Indaver Rivenhall IWMF DCO

# **Applicant's Comments on Deadline 3 Submissions - Noise Technical Note**

**Document Reference: EN0101038/APP/9.4.4**

**RE: Rivenhall IWMF DCO - Jacobs Review of Noise Modelling and Updated Cumulative Assessment**

Figure 8.3: Predicted Night-time Specific Sound Level at Grid Height of 4.0m – dB(A)

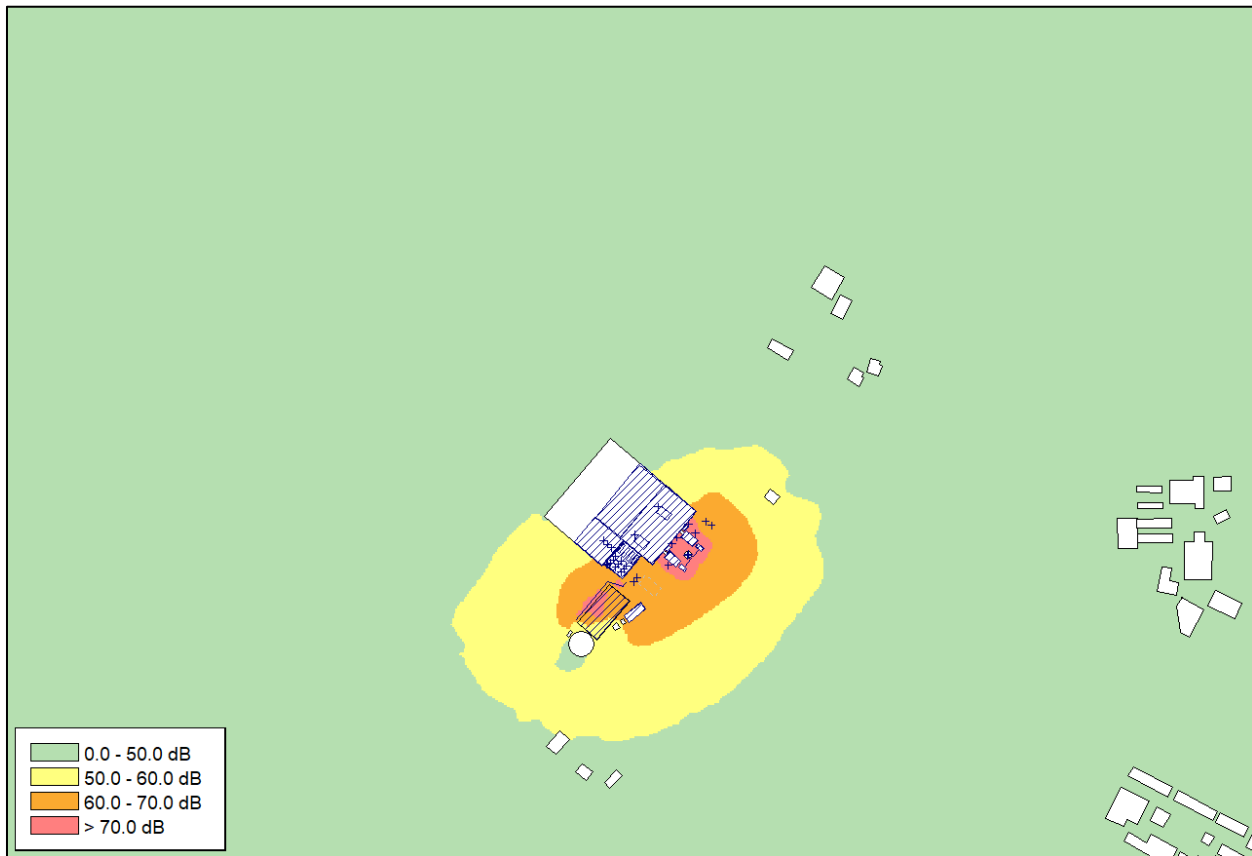
There are also potential sources of noise over prediction identified in the review, such as the receiver height at The Lodge (worst-affected receptor) at night and the omission of source directivity for noise sources where the noise propagation path is off-axis.

### **SLR Response 3**

With regards to The Lodge, as this has been identified as a bungalow, the night-time receiver height has been reduced to 1.5m and the building height reduced to 4m.

With regards to the noise source which could be considered off-axis, namely the stack, as recommended by Jacobs this has been re-modelled, so the point sources are acting as a Chimney with:

- A directivity in the 'Z' axis i.e. pointing upwards.

- An exhaust velocity of 20m/s (which has been confirmed with the operator).
- An exhaust gas temperature of 250°C (which has been confirmed with the EPC contractor).
- A Wind Speed of 3m/s.

These updates have not made a material impact on the assessment and the overall conclusions remain as reported within the ES Chapter [APP-033].
